Heckington Fen Solar Park

EN010123

Statement of Common Ground with Natural England

Document Reference: 7.6i

Drawing file: EN010123 / EN010123-000554-6.3.8.12 - Appendix 8.12 - Biodiversity Net Gain Calculation - Rev 2.pdf

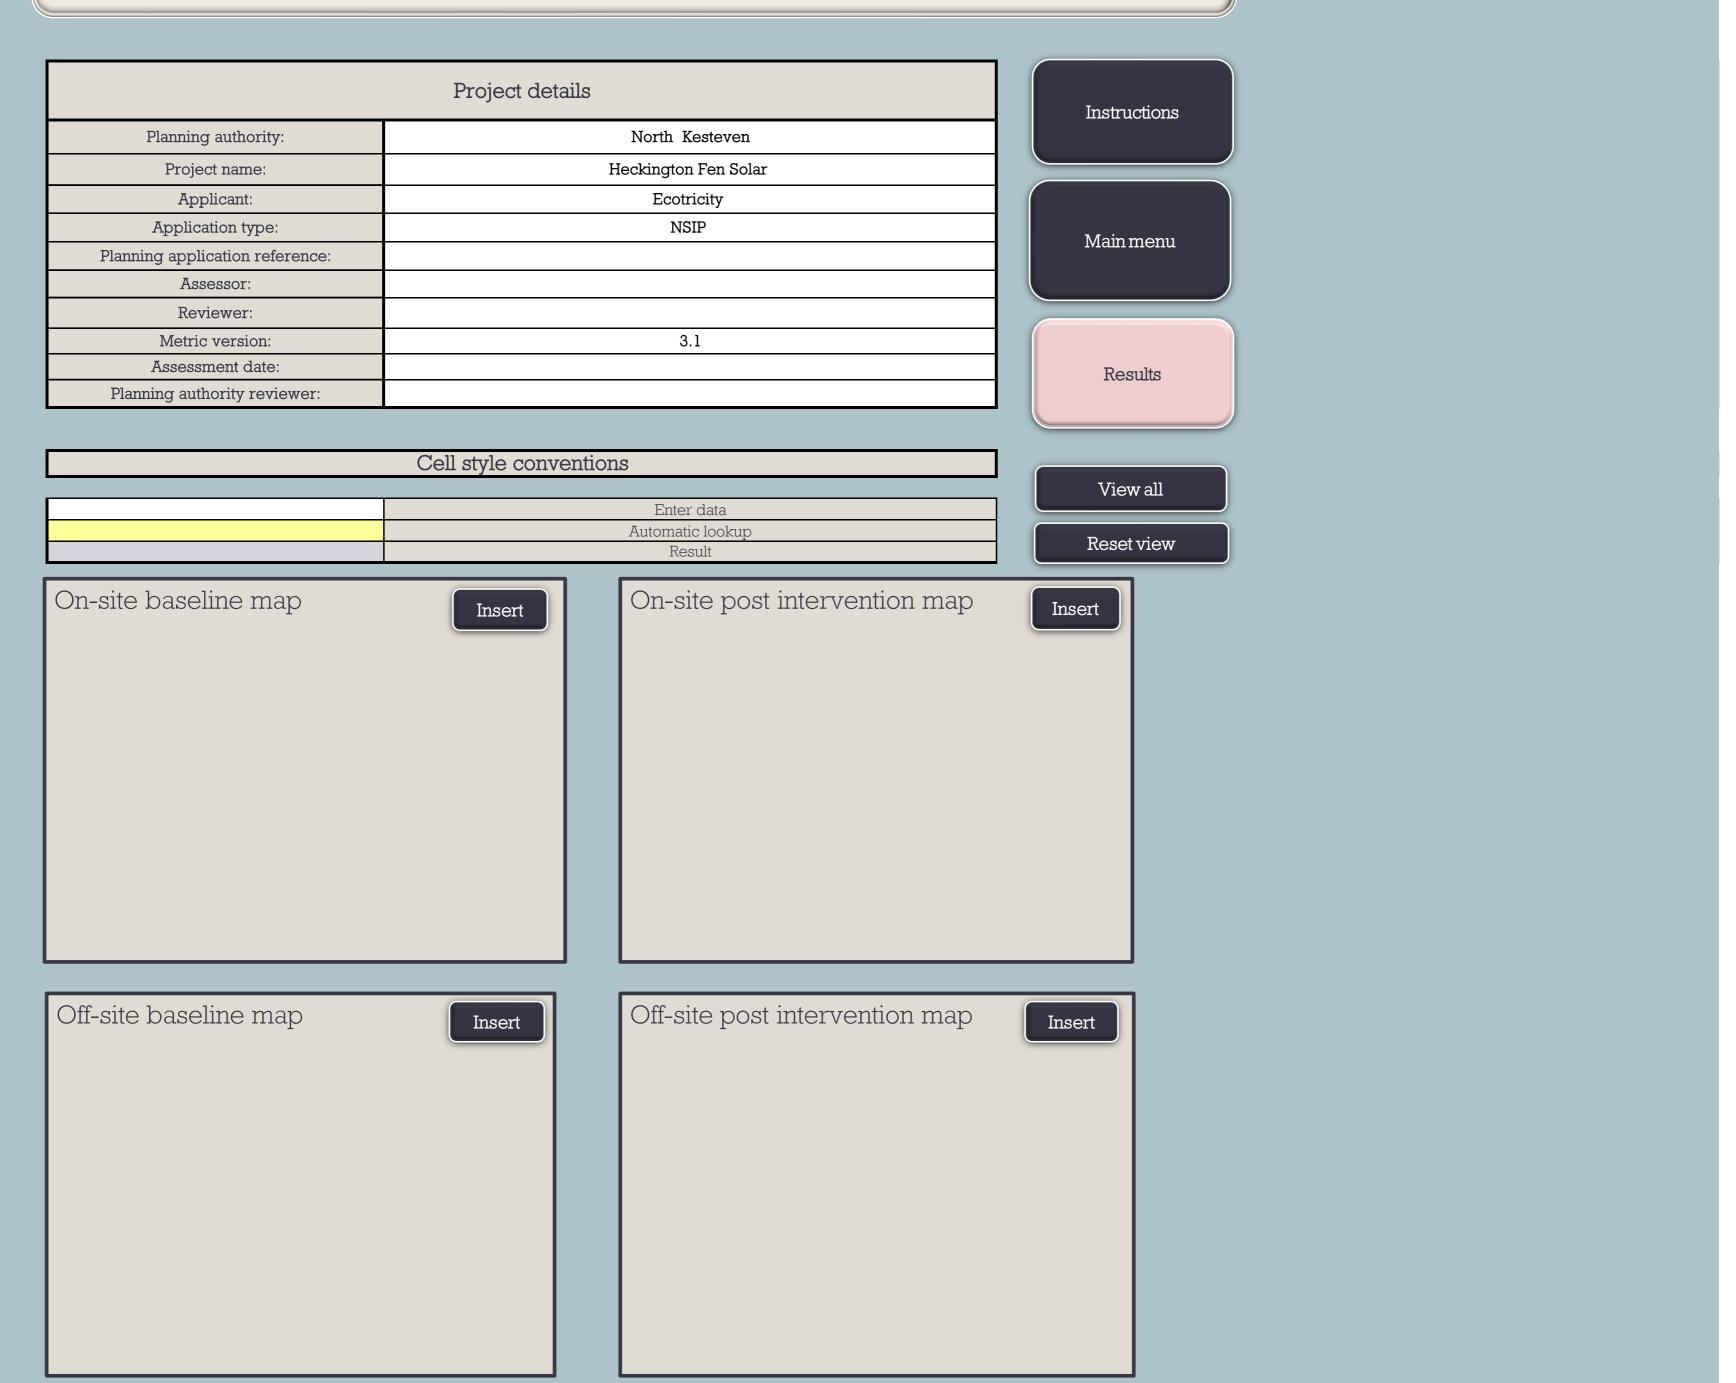
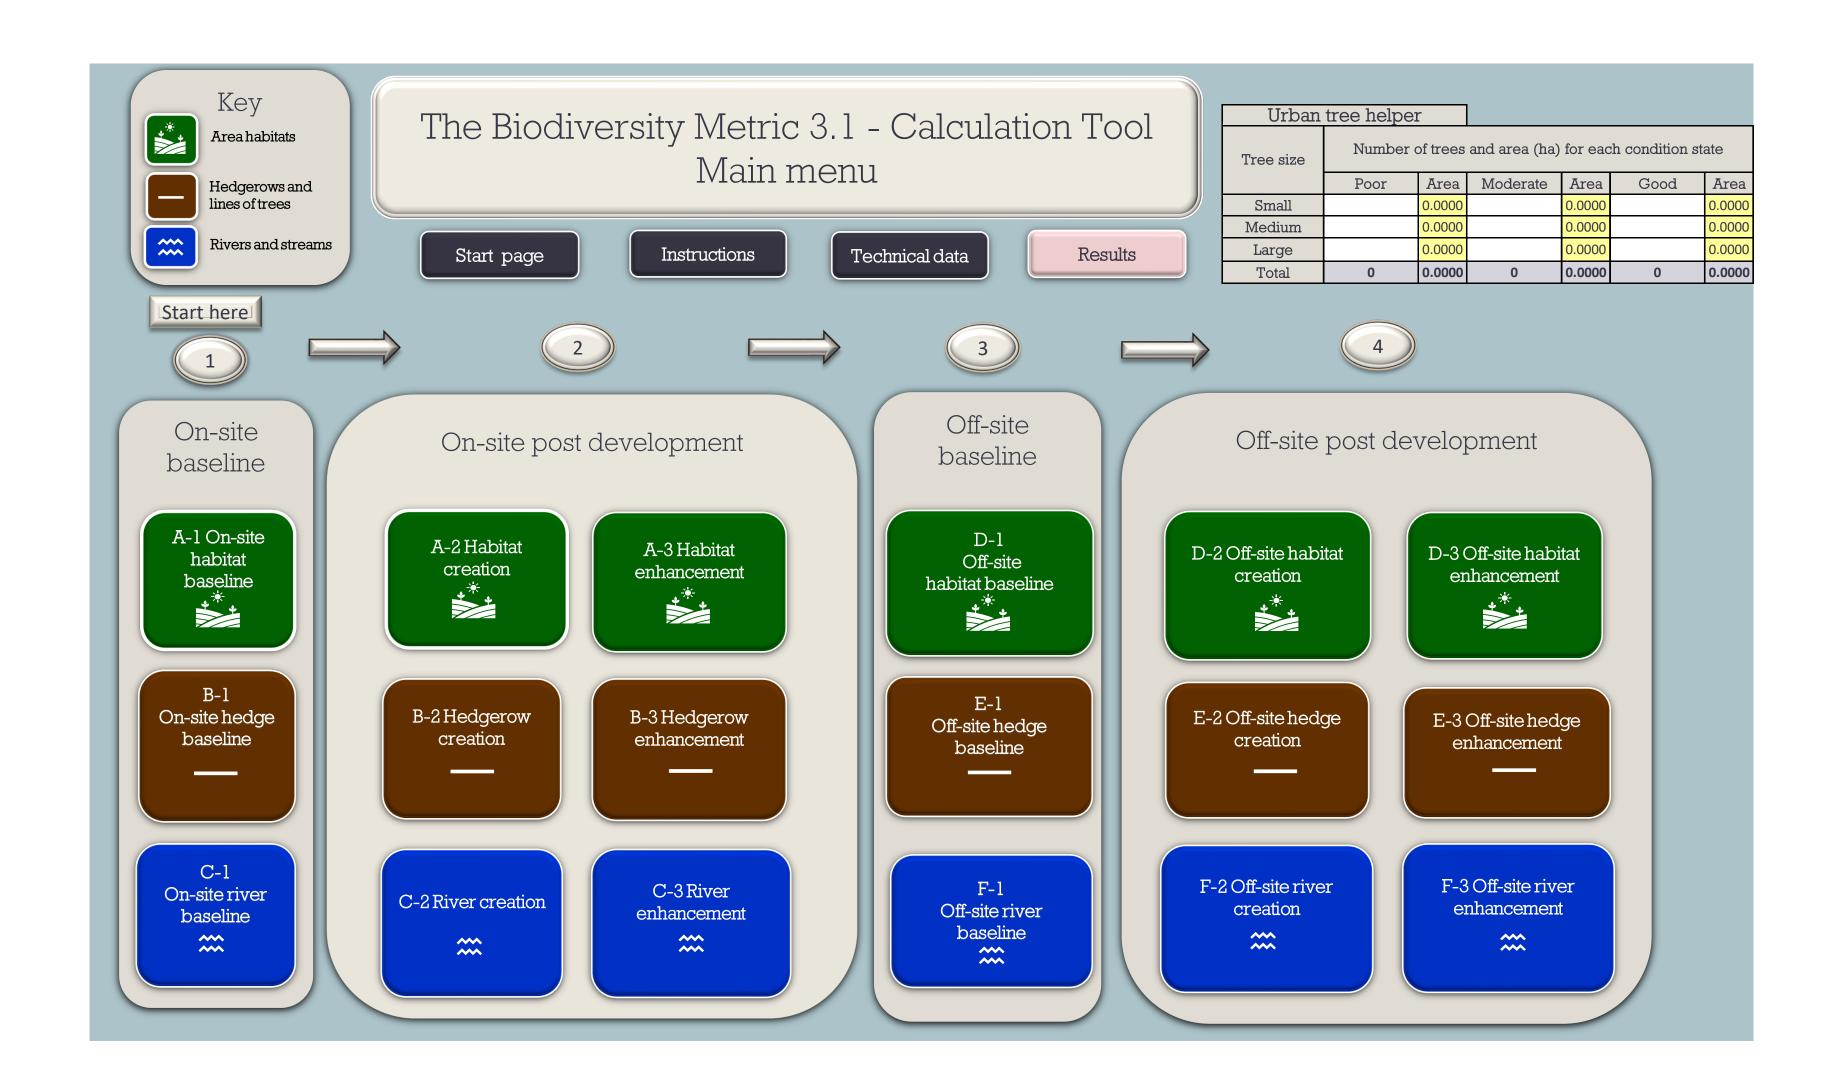
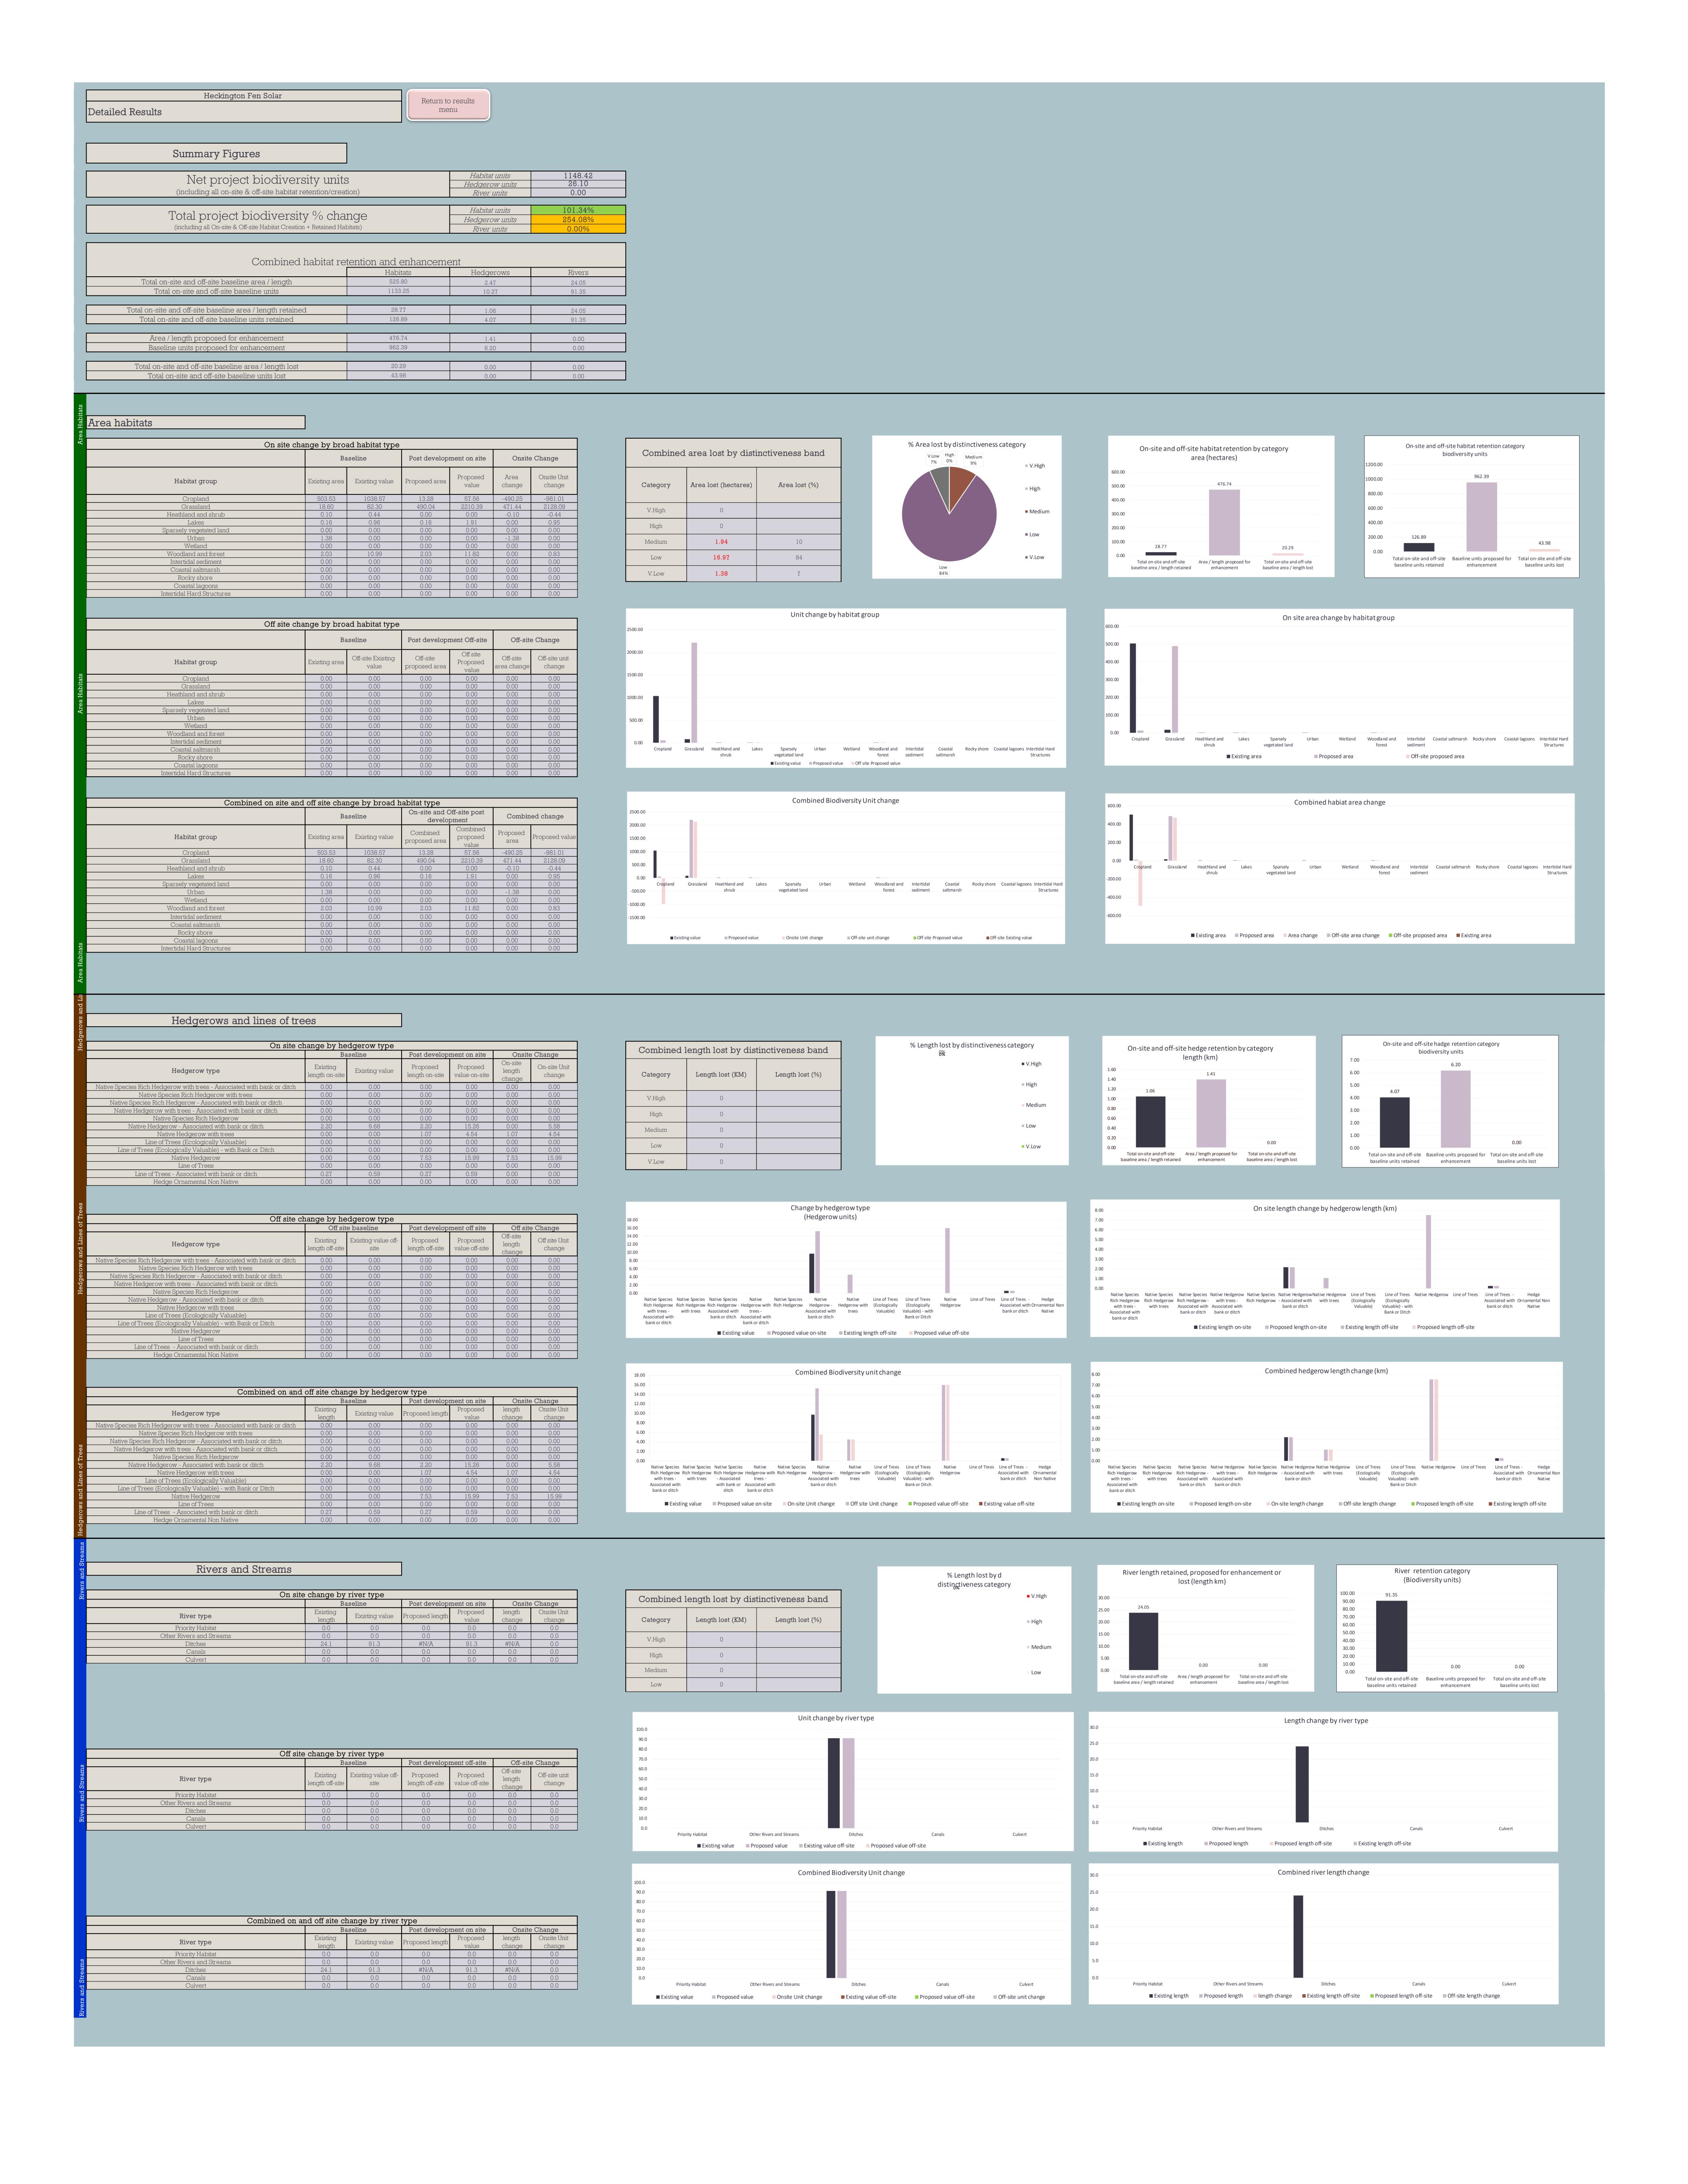
6. Biodiversity Net Gain			
6.1 Under	Biodiversity Net Gain	NE welcomes the commitment to deliver BNG	The Applicant notes NE's comments made

Reference and Status	Topic	NE’s Position	Applicant’s Position
DiscussionAgreed	Metric 3.1 used (Appendix 8.12) provided to NE on 20 th June 2023.	and is generally supportive of the enhancements proposed through the development. The enhancements detailed within the oLEMP, are welcomed and are likely to indirectly have a positive effect.	in relation to BNG during consultation which are generally supportive of the enhancements proposed, and detailed in the oLEMP.
